# **Sheringham Shoal and Dudgeon Offshore Wind Farm Extension Projects**

Traffic and Transport Discussions with  
Norfolk County Council

Title:	
<b>Sheringham Shoal and Dudgeon Offshore Wind Farm Extension Projects Examination submission Traffic and Transport Discussions with NCC</b>	
PINS document no.:	
Document no.:	
Date:	Classification
<b>10.01.2023</b>	<b>Draft</b>
Prepared by:	
<b>Royal HaskoningDHV</b>	
Approved by:	Date:
<b>Sarah Chandler, Equinor</b>	<b>XX</b>

**Table 1-1 NCC Comments on SEP and DEP DCO documents and the Applicant's response**

TITLE  
**A47 EASTON DRAFT ACC47 ACCESS DESIGN (SHEET 1 OF 2)**

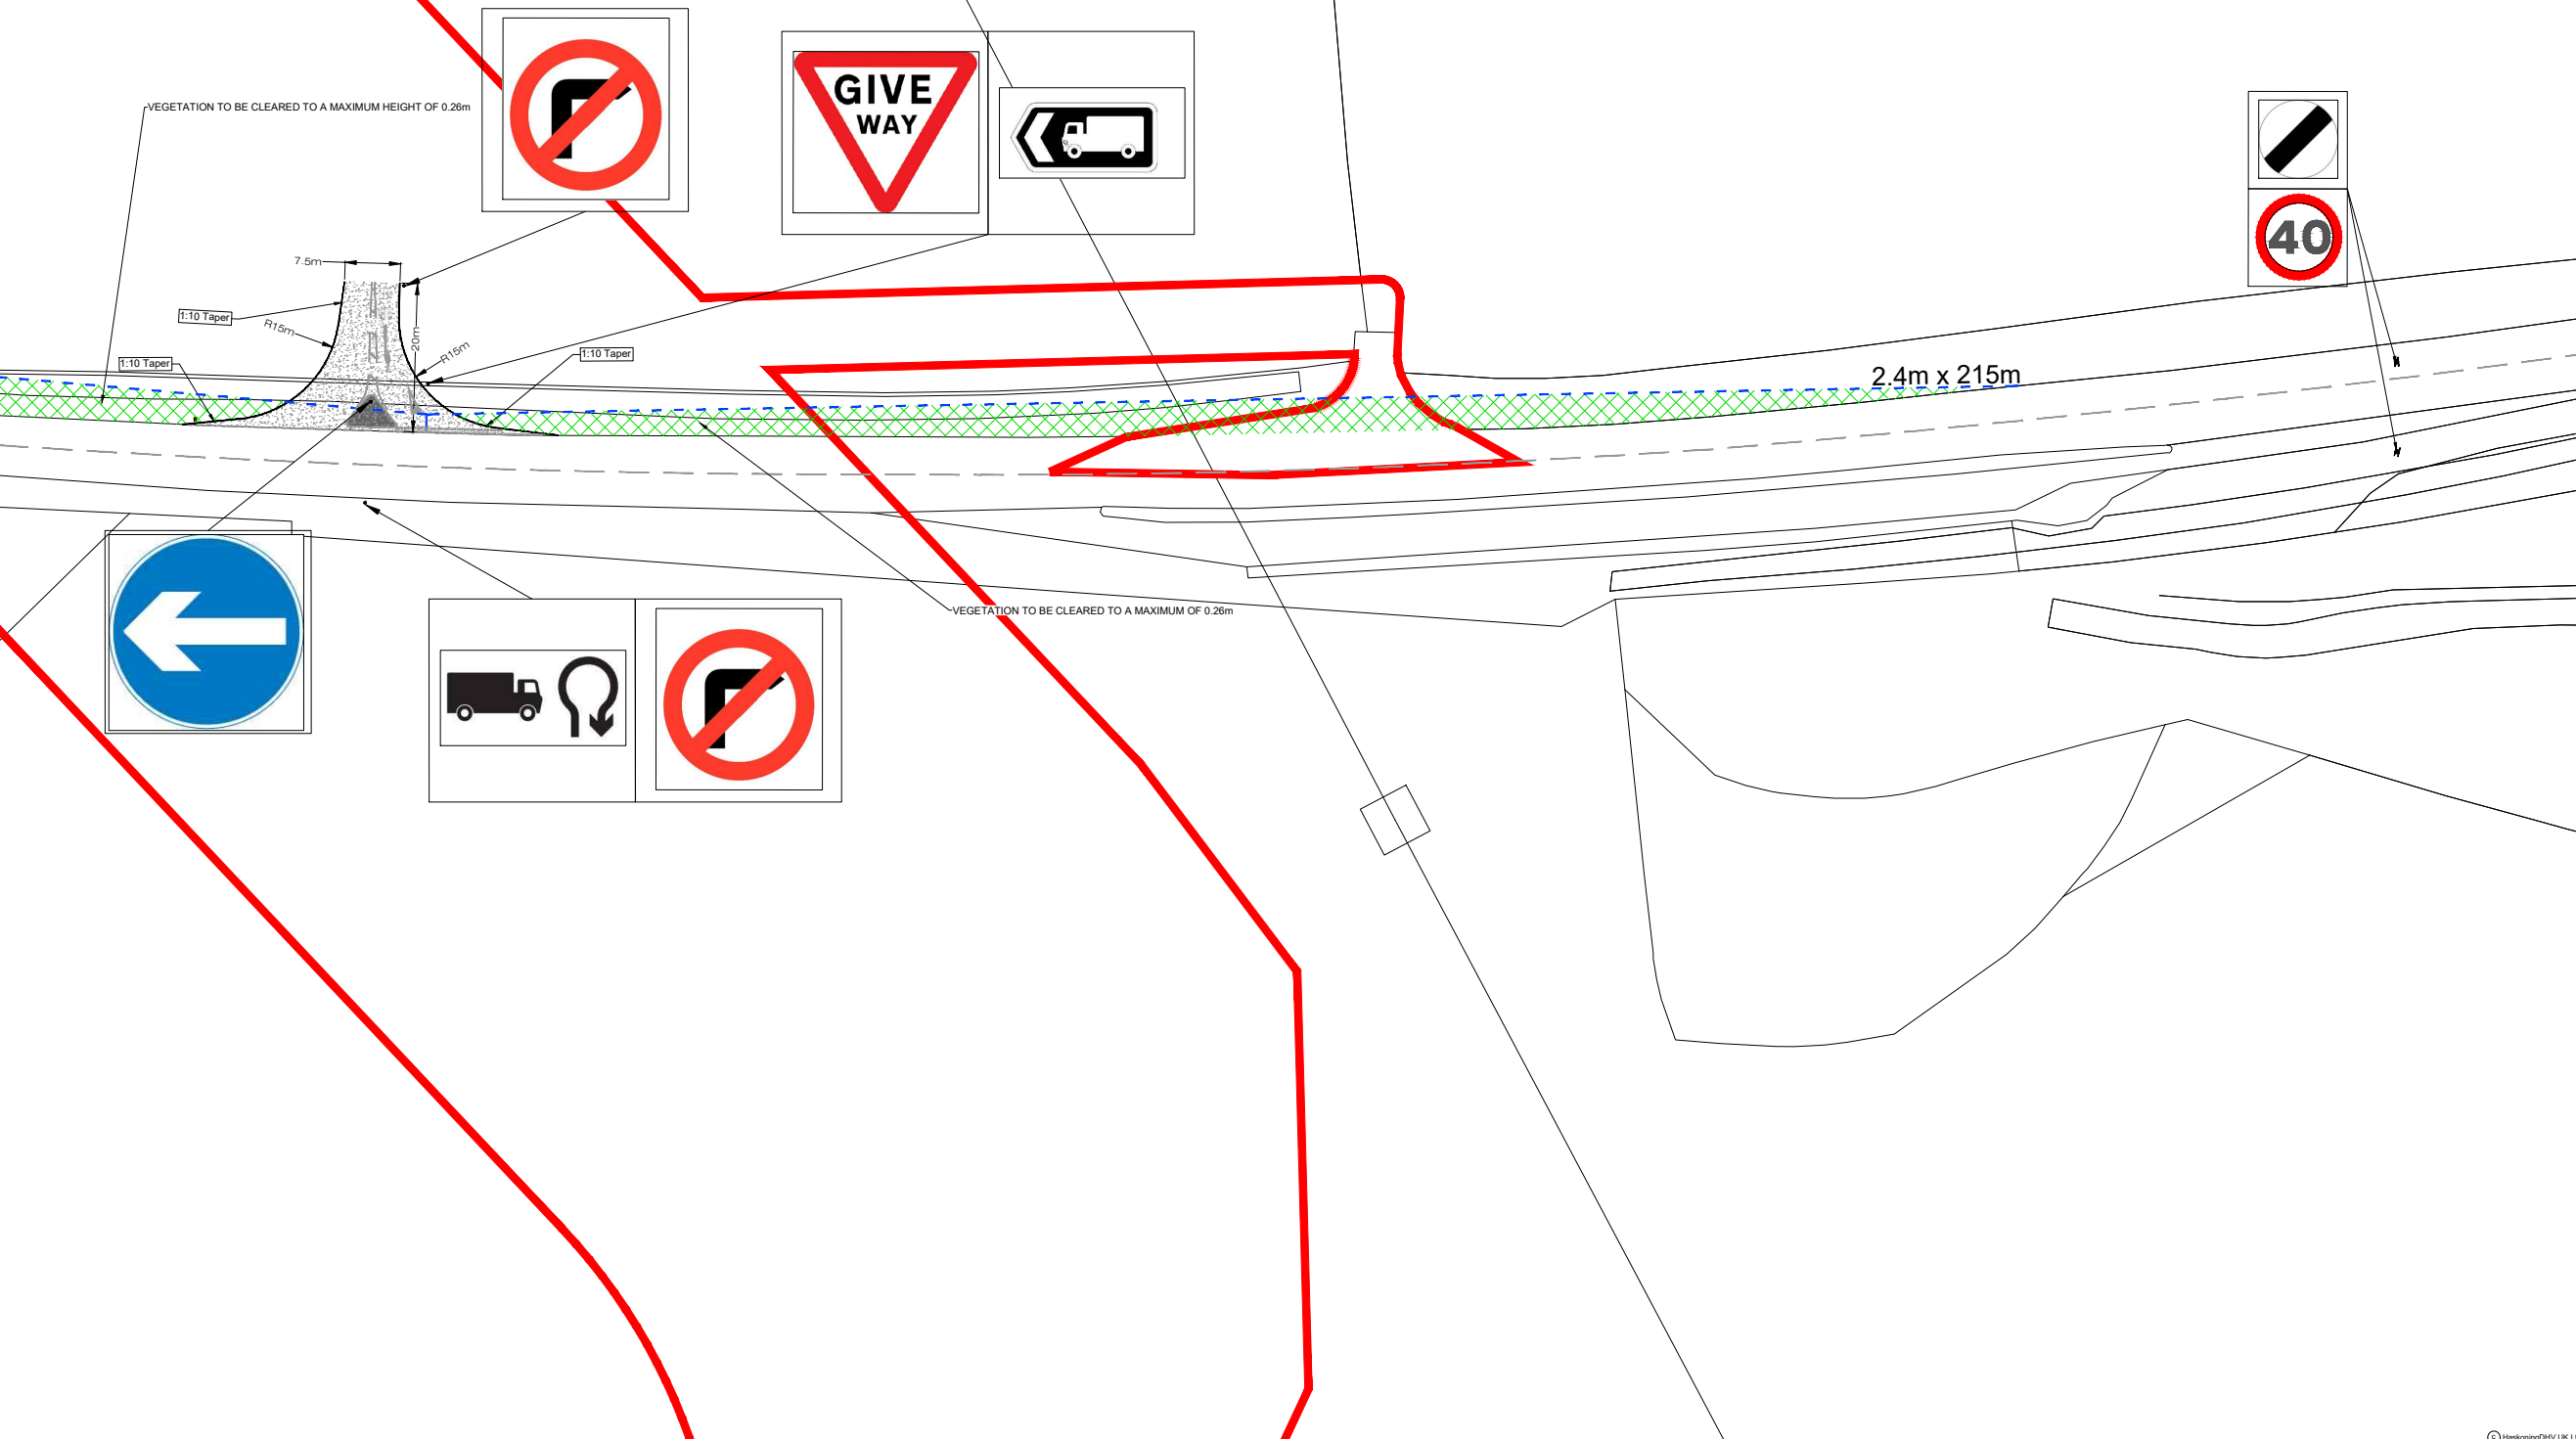
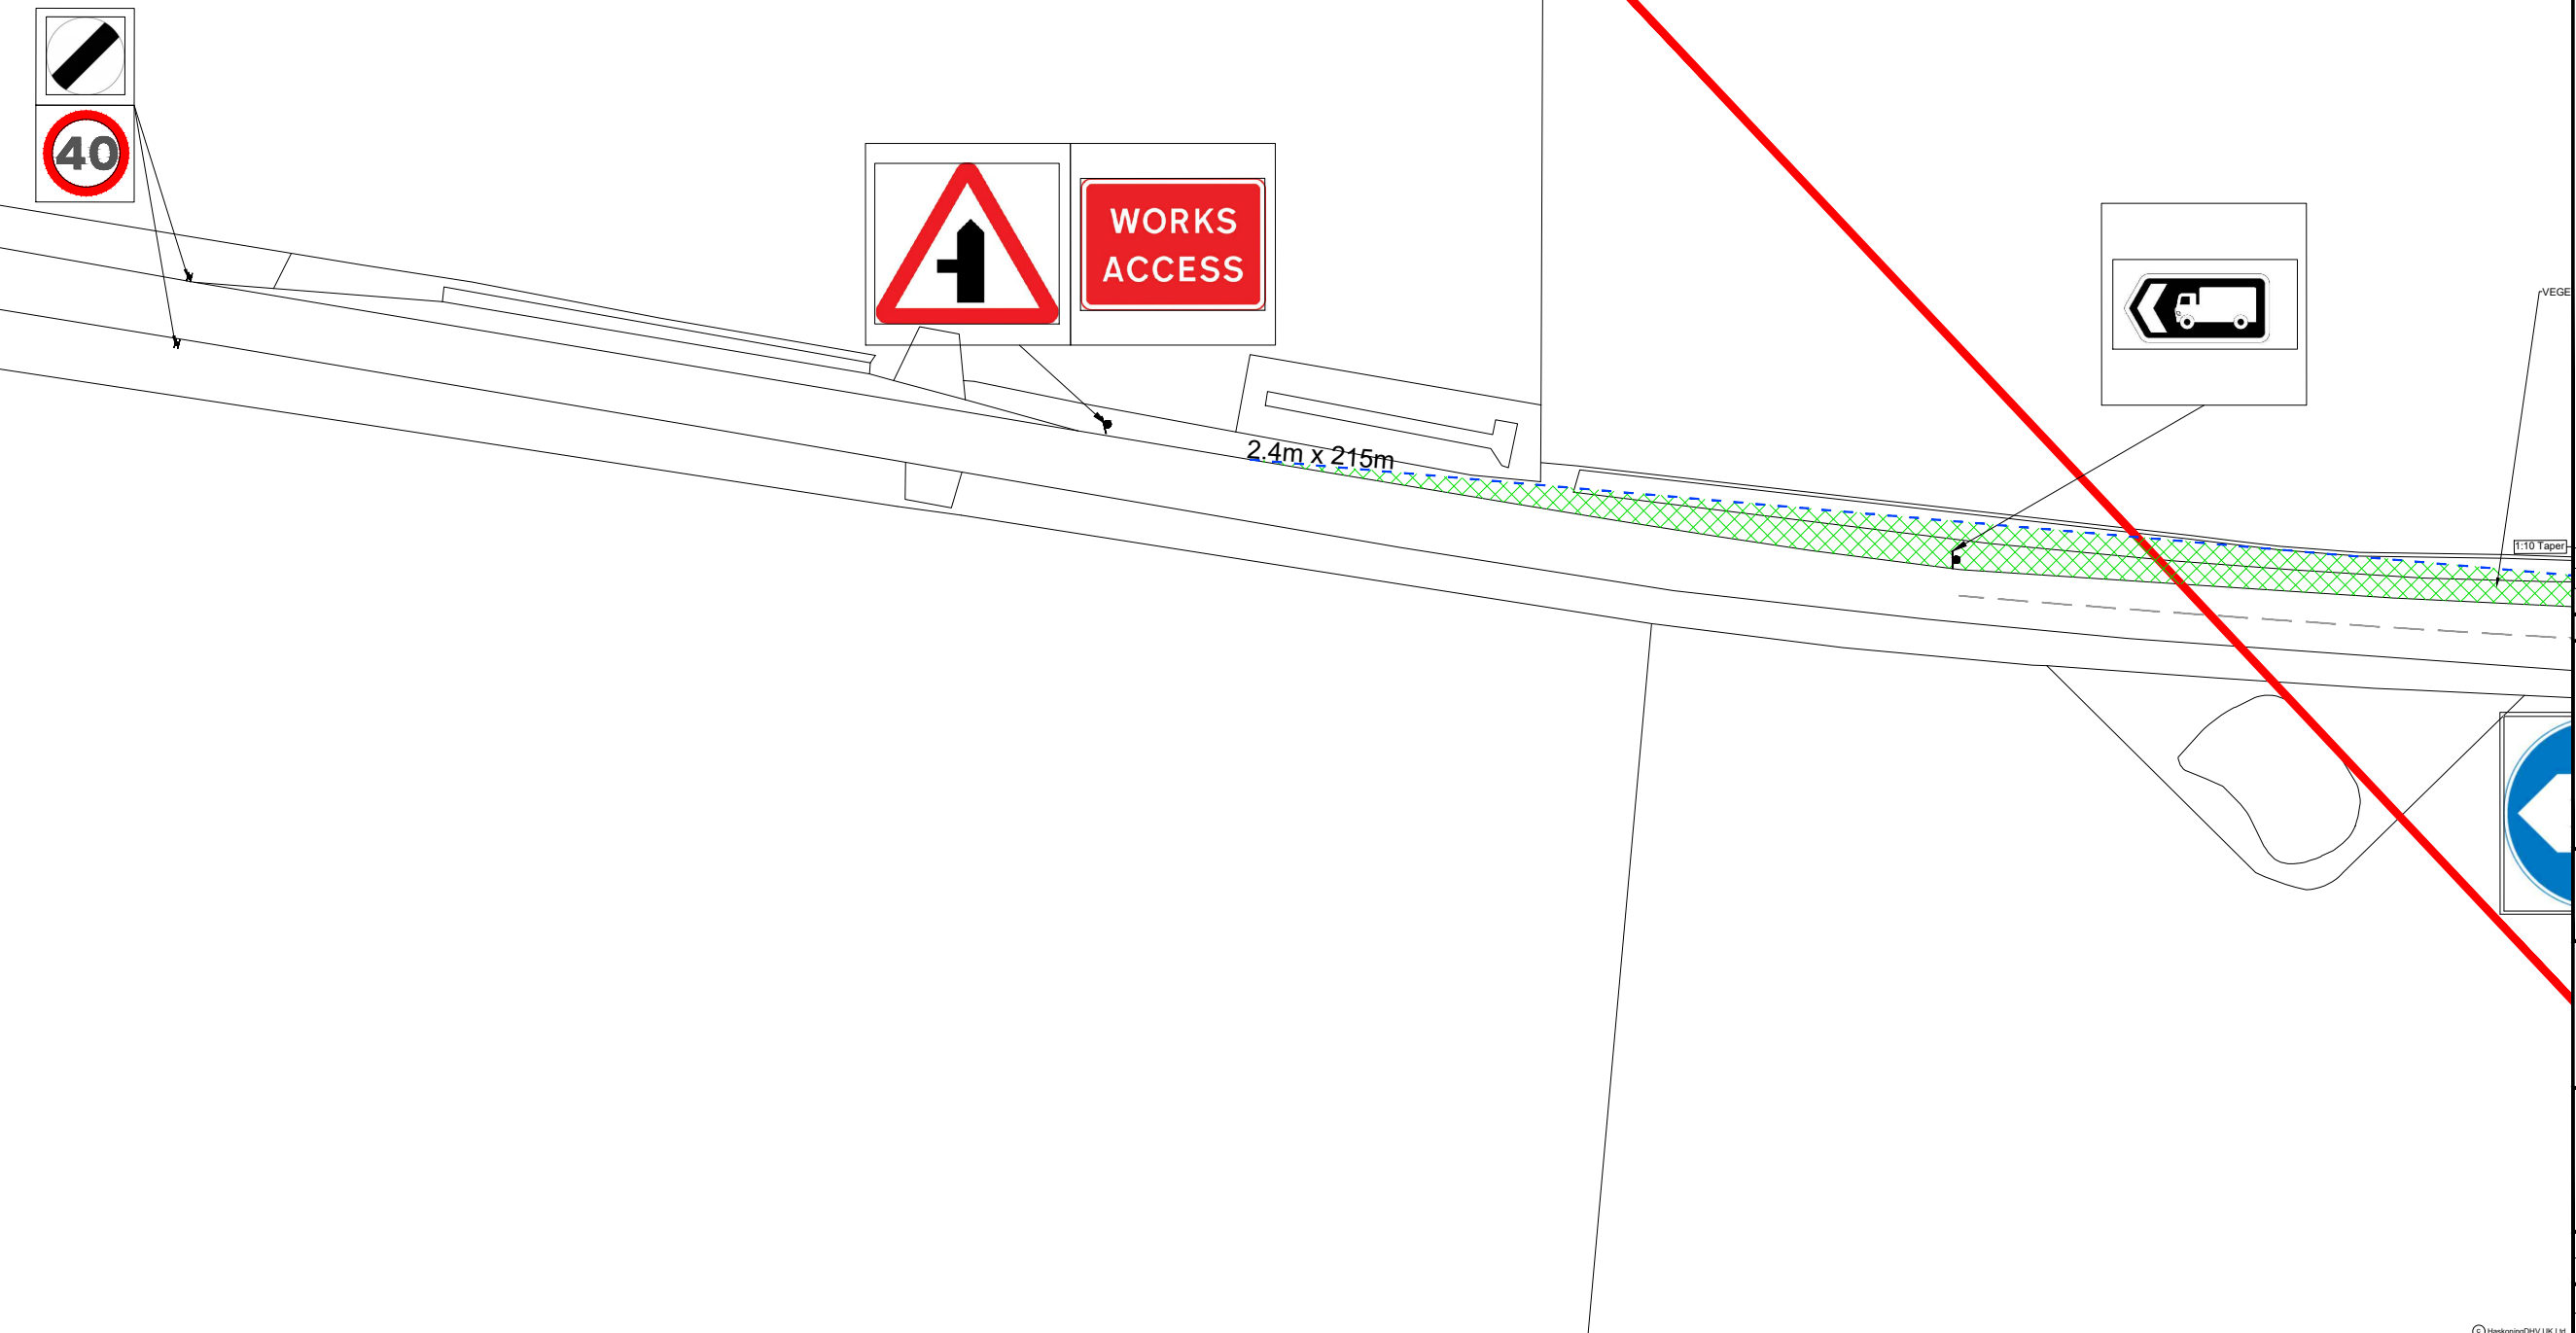
20		Sheet 28 Easton compound – need to factor in the Blind Lane closure for the A47 Tuddenham works	<p>Chapter 24 of the ES [APP-110] outlines that access to ACC49 will be provided from the unnamed road (link 93) that heads southwest from the A47 roundabout. No HGV traffic would be routed via Blind Lane. This commitment is contained within the OCTMP [APP-301] which is secured via Requirement 15 of the draft DCO [APP-024]. Figure 1 of the OCTMP contains the permitted HGV routes and it can be identified that no HGVs are permitted via Blind Lane and that HGVs will instead be required to use link 93. Section 2.3 of the OCTMP sets out how the routing of HGVs will be controlled.</p> <p>Annex 19 of the TA [APP-269] outlines the forecast numbers of peak daily vehicle trips that could travel to ACC49. This identifies that at peak, there could be up to 37 HGV trips per day, equivalent to two arrivals and two departures an hour. In addition, Annex 23 of the TA [APP-269] identifies that there could be a peak of up to 40 LV trips per day, equivalent to 20</p>	NCC confirmed that they are content with the clarification provided and that the measures outlined within the OCTMP to manage traffic movements are appropriate.
